**Transport  
for NSW**

**RPA Hospital Multi-storey Carpark (SSD 7542)  
Notice of Exhibition**

## **TAB A – Request for Further Information/Clarification**

Figure 9: Estimated traffic distribution – peak period arrivals and departures (green arrow AM arrivals, red arrow PM departures) (source: EIS)

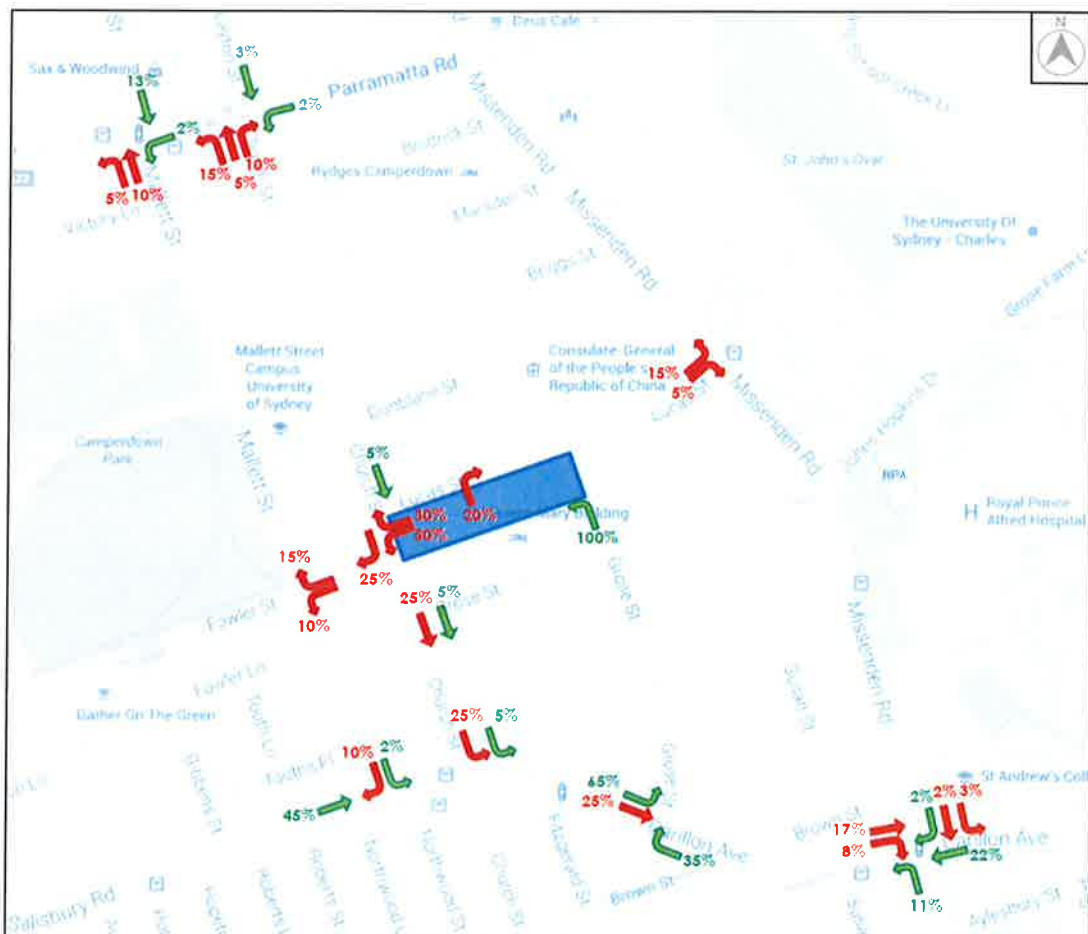
Section 6.2 of the Transport Impact Assessment (TIA) provides an assessment of directional distribution and assignment which was based on various factors (such as road network configuration, employee residence locations). Figure 6.1 of the TIA graphically depicts the distribution and assignment assumptions. Further clarification is required on the following:

- It is indicated that 20% of development traffic exiting the site would be heading west along Parramatta Road in the PM Peak, however 0% of development traffic entering the site would be arriving from the west along Parramatta Road.

- It is indicated that 15% of development traffic existing the site would head north along Missenden Road, however no development traffic is shown turning at the intersection of Missenden Road/Parramatta Road.

It is requested that the proponent clarify the traffic distribution and assignment assumptions particularly for development traffic to/from the west along Parramatta Road and development traffic turning movements at the intersection of Missenden Road/Parramatta Road.
